**Town & Country Planning Act 1990 (as amended)
Town & Country Planning (Development Management Procedure) (England) Order 2015: Article
39**

**Application for Lawful Development Certificate for an Existing Use or Operation or Activity
including those in breach of a planning condition.**

Development Lawful development certificate for an existing dance school.

Location The Old School Bersted Street Bognor Regis

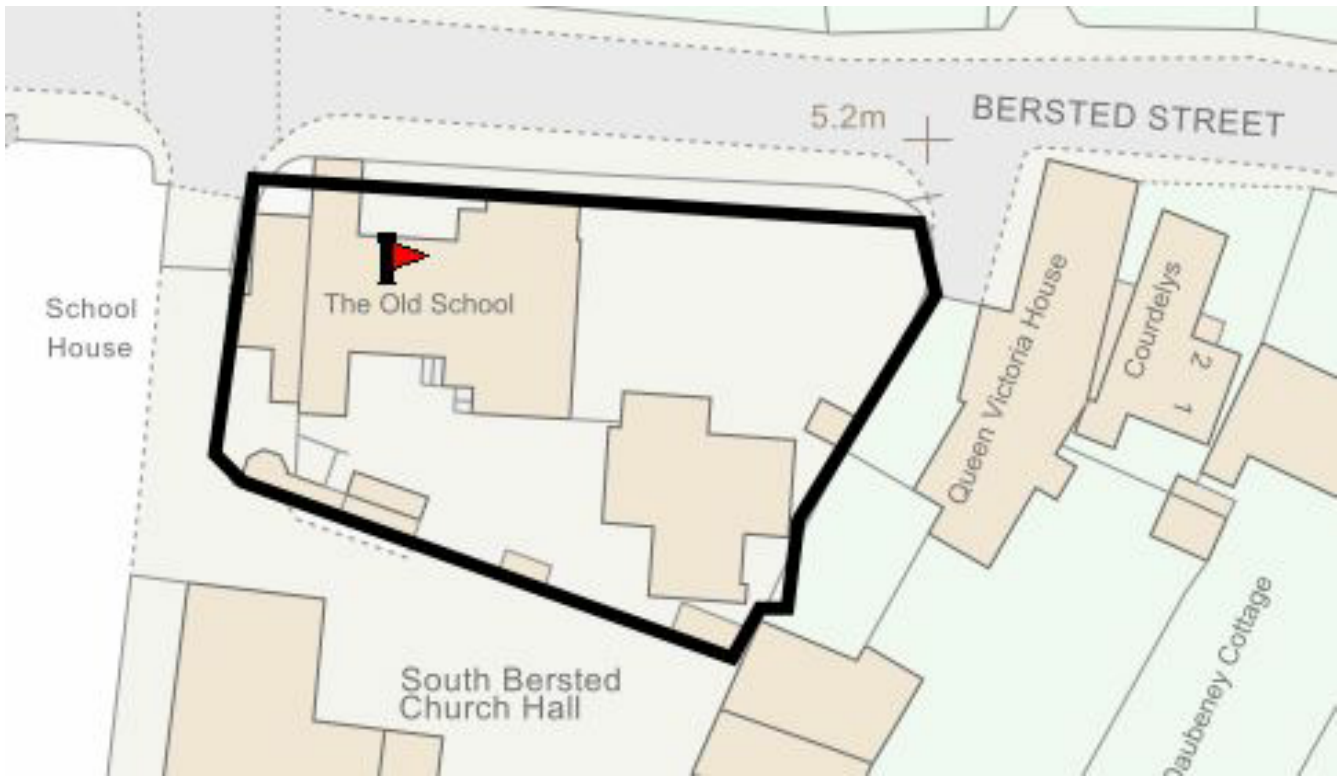
Location Plan Amend

Please only red edge the part of the school(s) being used as a dance studio.
